# CITY OF ALBUQUERQUE

October 23, 2018

RE: **Oso Bio Syringe Line**  
**4401 Alexander Blvd NE**  
**Grading and Drainage Plan for Building Permit**  
**Engineer's Stamp Date 10/16/2018 Disapproved**  
**Hydrology File: F16D003B1**

<b>OSO BIO SYRINGE LINE DEMOLITION PLAN</b>		
DRAWN BY:	DATE:	
CHECKED BY:	PROJECT NO. 20190058	SHEET NO. <b>C1.0</b>

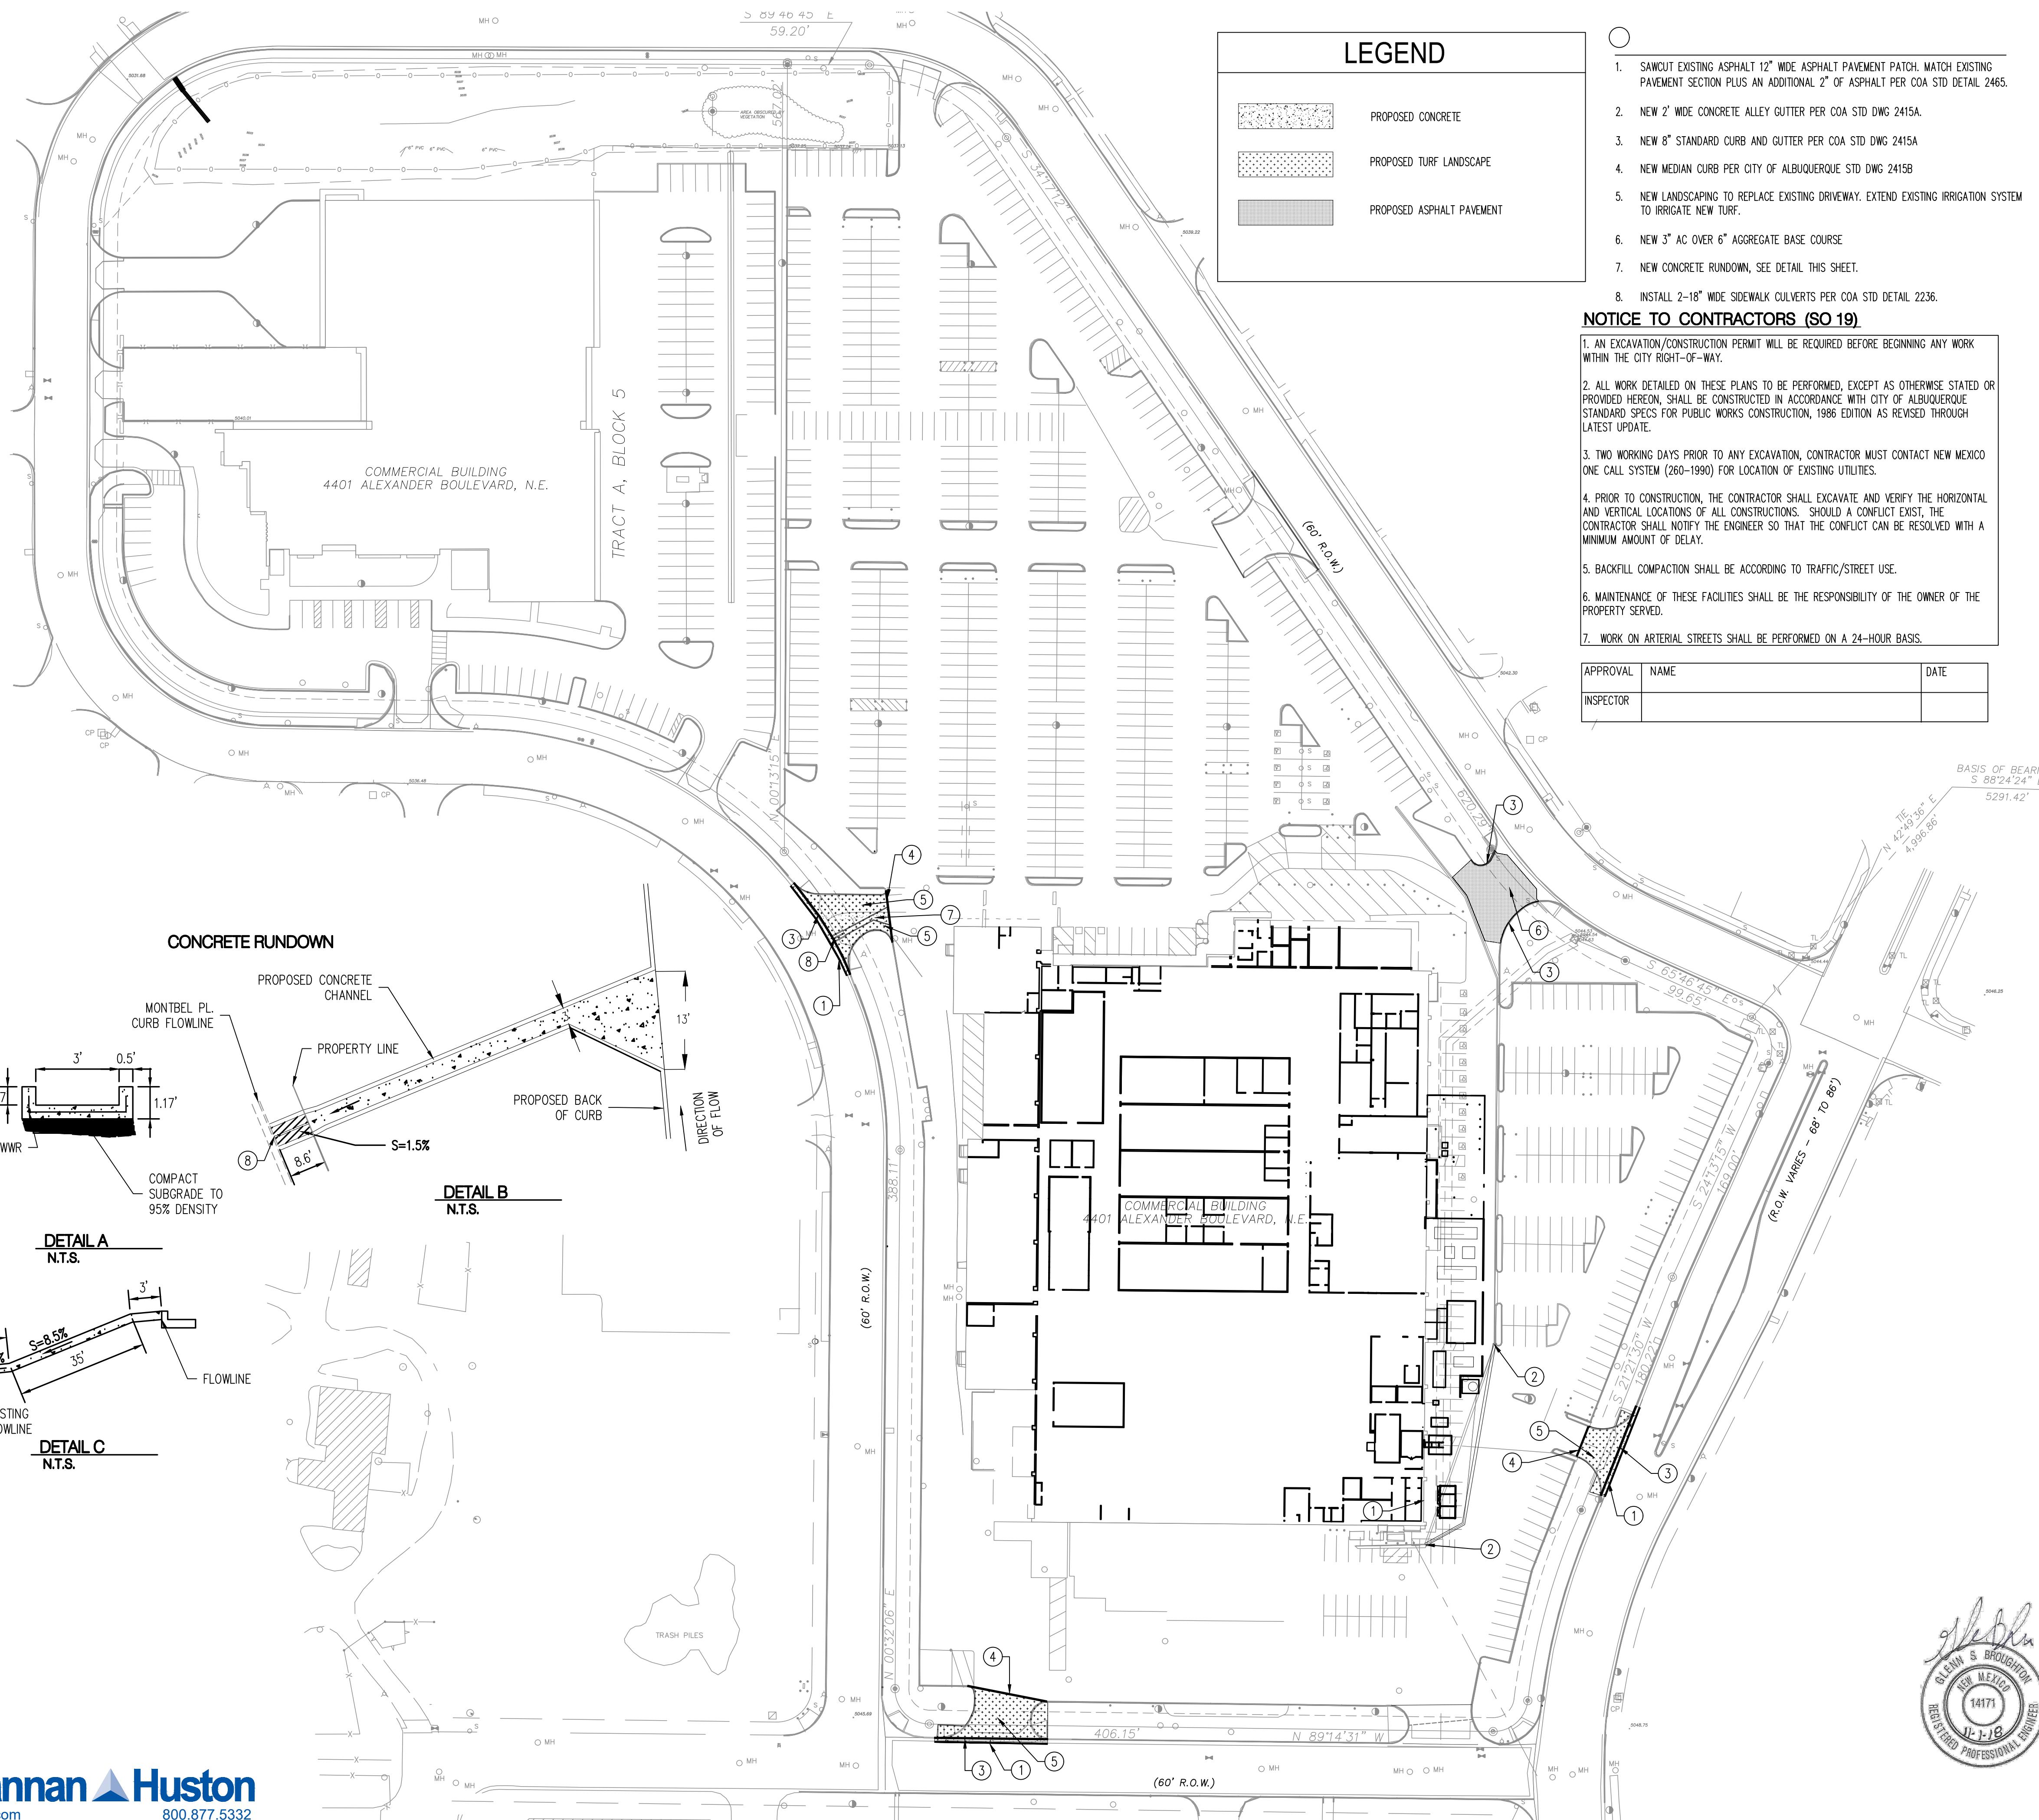
3. The concrete rundown at the Montbel Pl driveway to be closed needs to include sidewalk culverts from ROW line to the face of curb to accommodate future sidewalks. The culverts will need to be ADA compliant (1.5% slope, 2% max) and constructed by SO-19 Permit. Confirm that the open channel calculation was made assuming a 1.5% slope (not 2% as shown) and update the calculations to reflect sidewalk culvert cross sections.

<b>OSO BIO SYRINGE LINE</b>		
<b>ENLARGED GRADING PLAN</b>		
DRAWN BY:	DATE:	
CHECKED BY:	PROJECT NO. 20190058	SHEET NO. <b>C1.3</b>

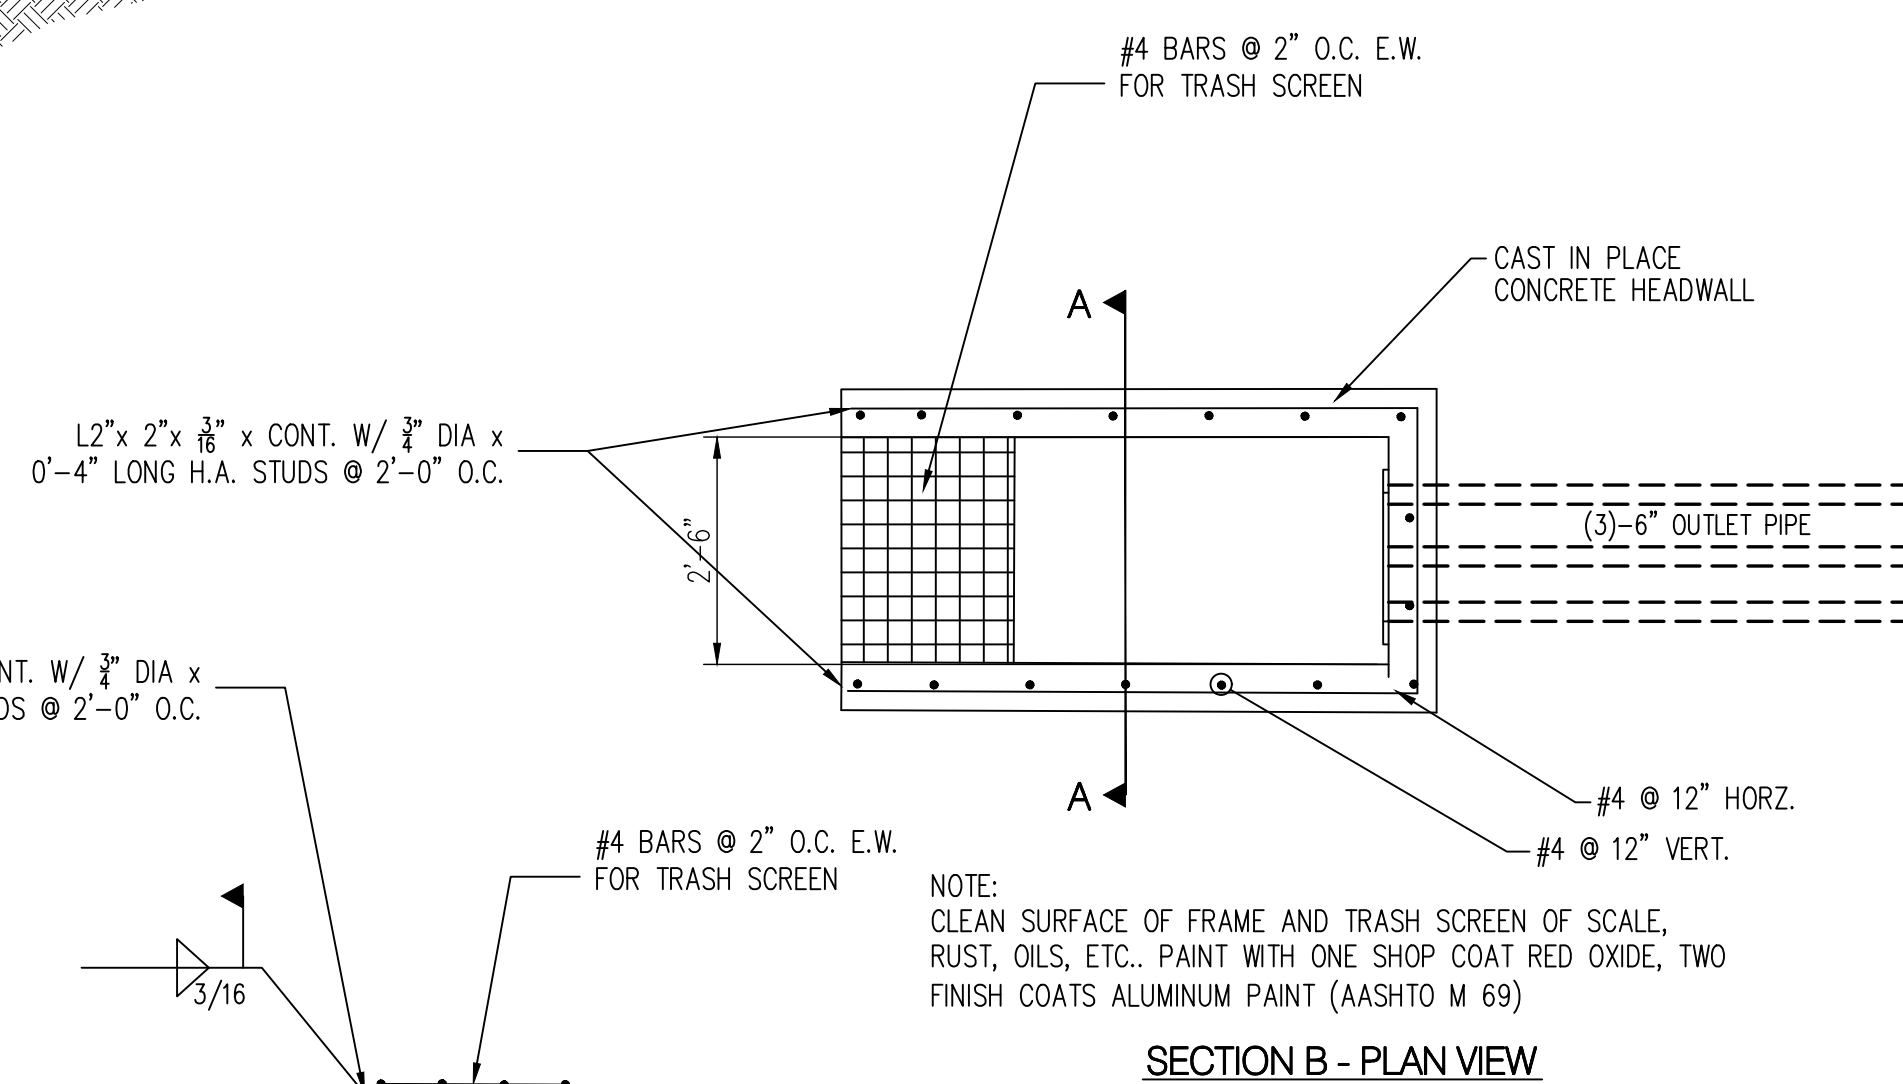
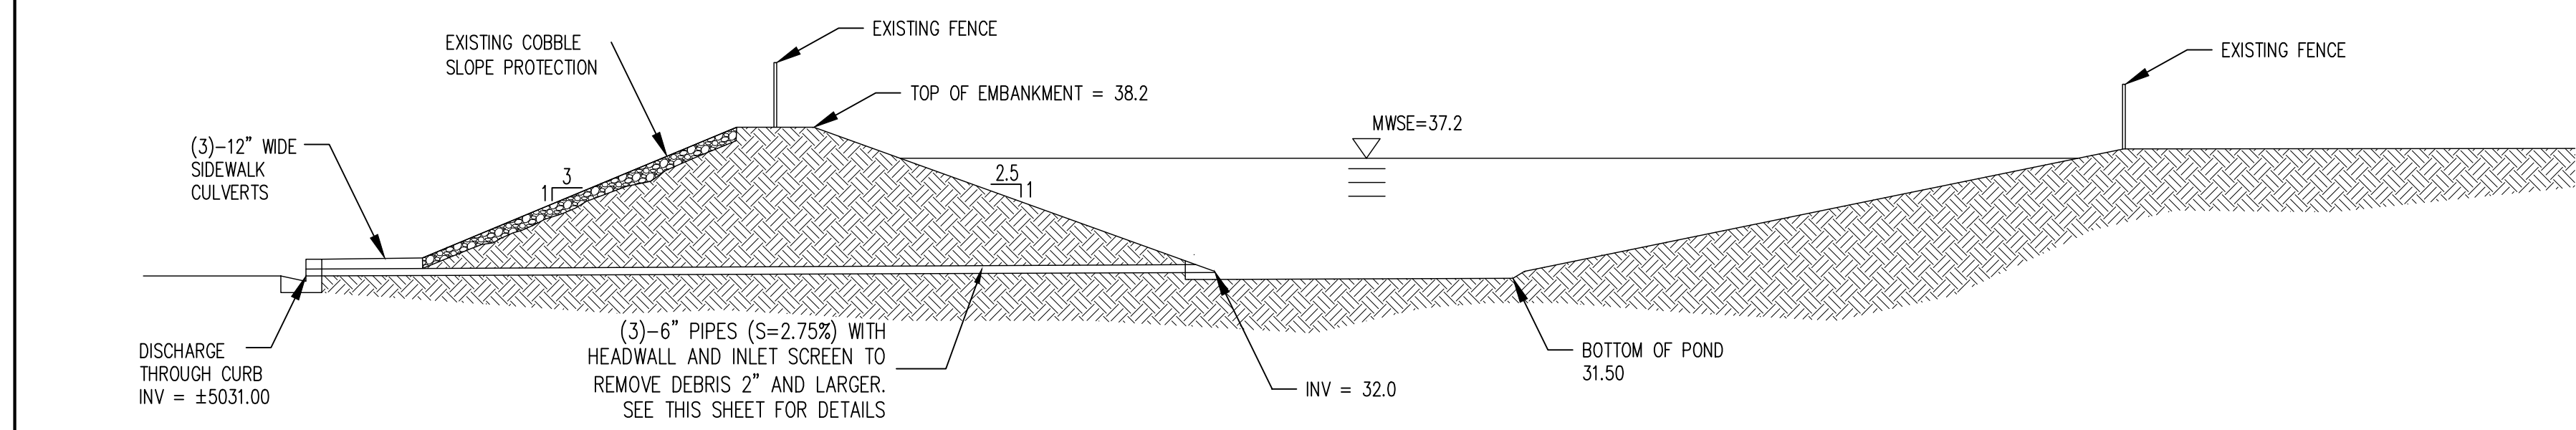
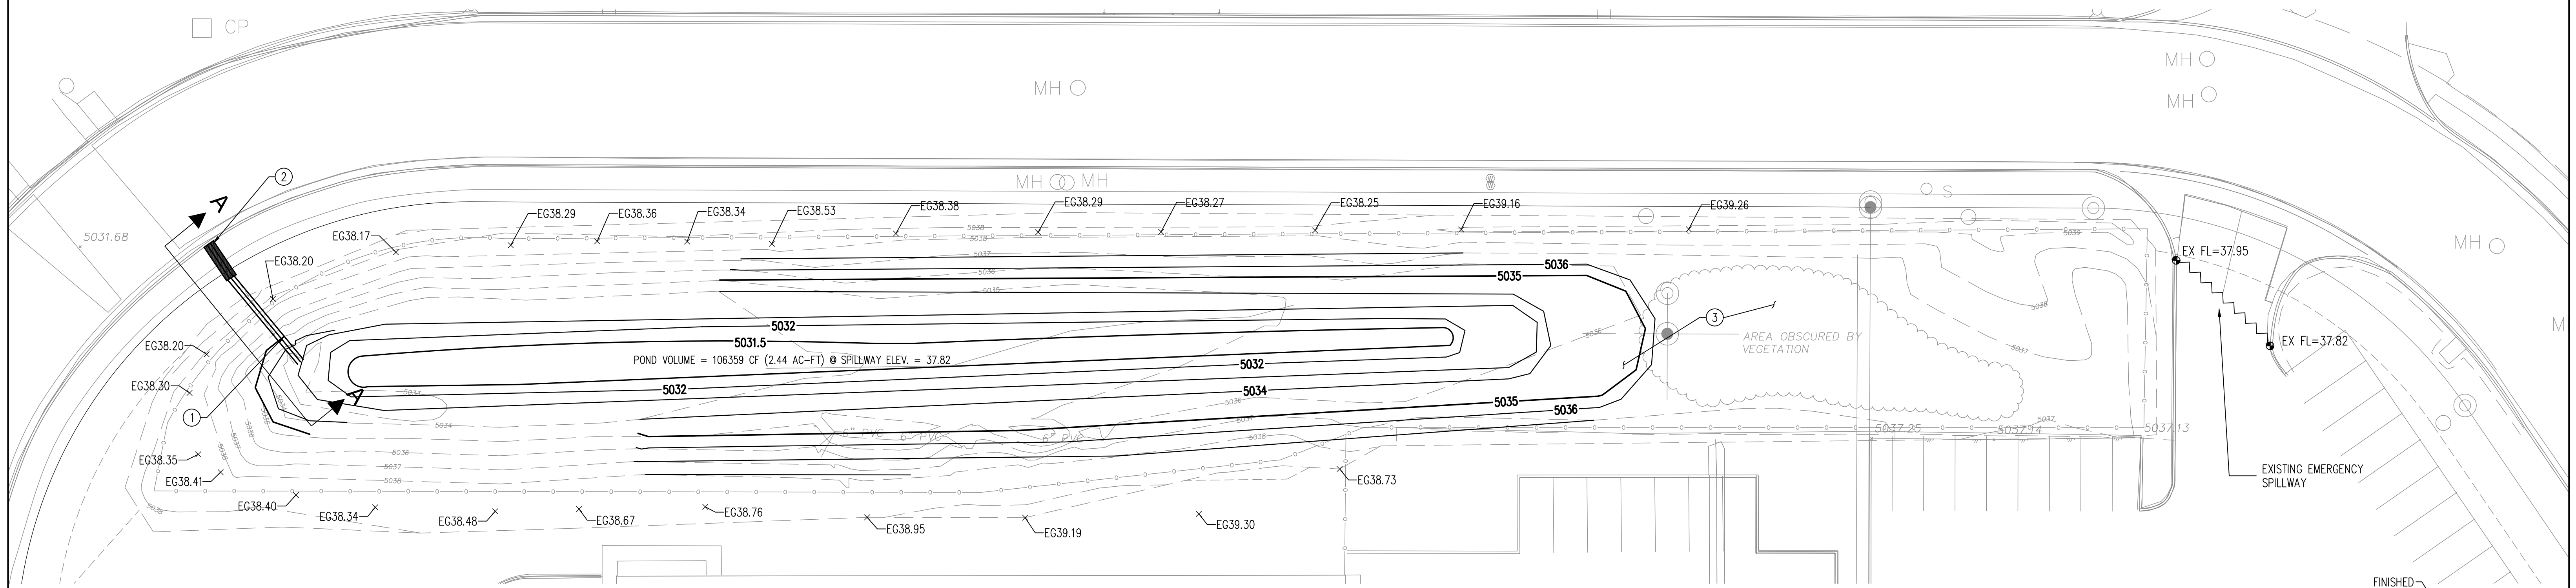
5. The proposed 100-yr WSEL needs to be shown on the pond in plan view and in the sections. Also, any trees/brush that are growing into the side of the berm (especially towards the east end) should be removed with this project.

6. Specify a grate to prevent clogging of the outfall pipes to be placed over the entire headwall/wingwalls of the outlet structure.
7. Exhibit 'A' to the drainage covenant needs to include the entire pond and its emergency spillway; the east side of the pond and the spillway are missing. The drainage covenant must be signed by the "owner" of the property that the pond is located on, Tract A. If a separate agreement between the two property owners, Tract A and Tract B, is required by the owner of Tract A, the City does not need to be a party to that agreement. The owner's signatures must be notarized and the original document together with a \$25 check payable to the Bernalillo County must be submitted to Madeline Carruthers on the 4<sup>th</sup> floor.
